## ASSESSMENT REPORT

### SITE 8C, SYDNEY OLYMPIC PARK SSD 6059 MOD 1

Figure 1: Elevation and Section of Proposed Portico (including indicative NRMA signage)

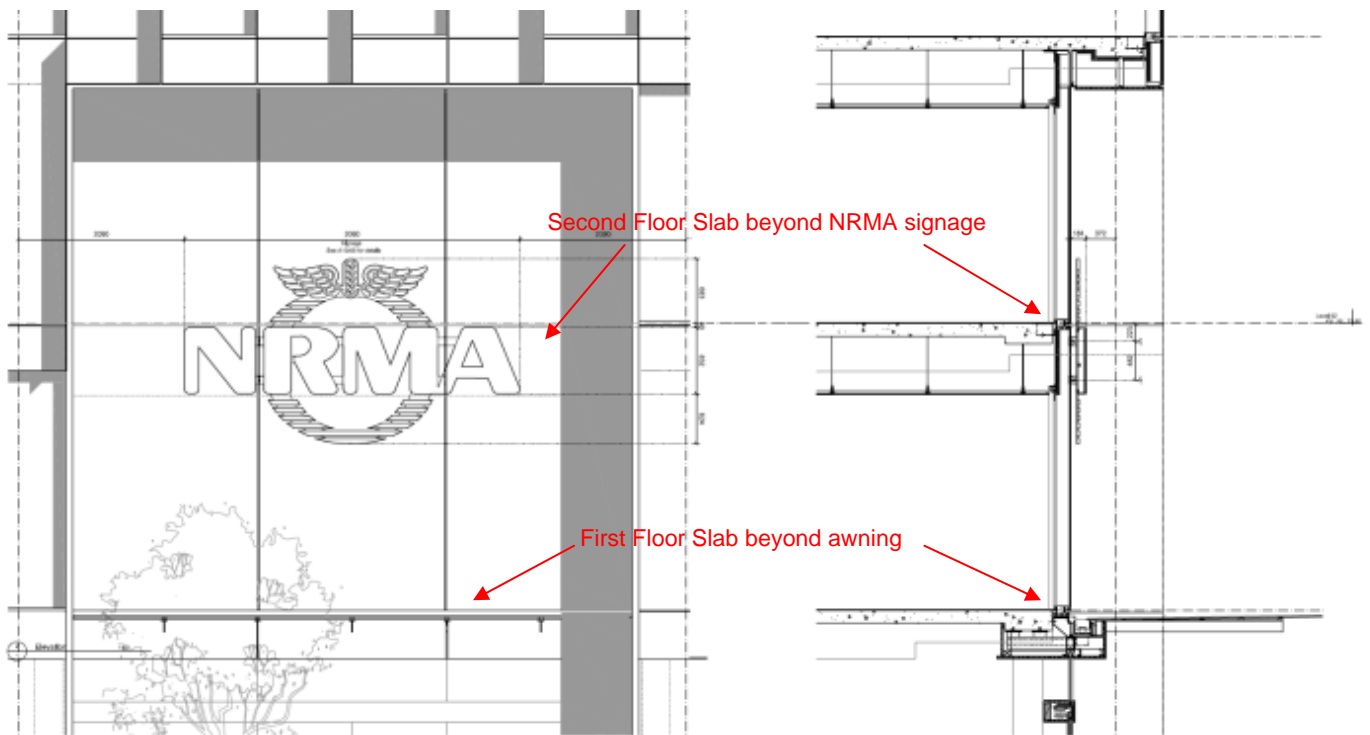
- the first and second floor slabs should be setback to create a three storey atrium behind the portico to reinforce the scale of the entry feature; and
- maximum glazing on the retail façade by providing frameless glass, or generously spaced mullions.

The applicant advised that an internal void behind the portico entry would not suit the desired internal layout sought by NRMA. SOPA accepted the applicant's response and subsequently

recommended that the building identification sign/logo should be installed in line with the second floor slab edge. The applicant has submitted detailed plans confirming the sign would be installed in line with the second floor slab edge.
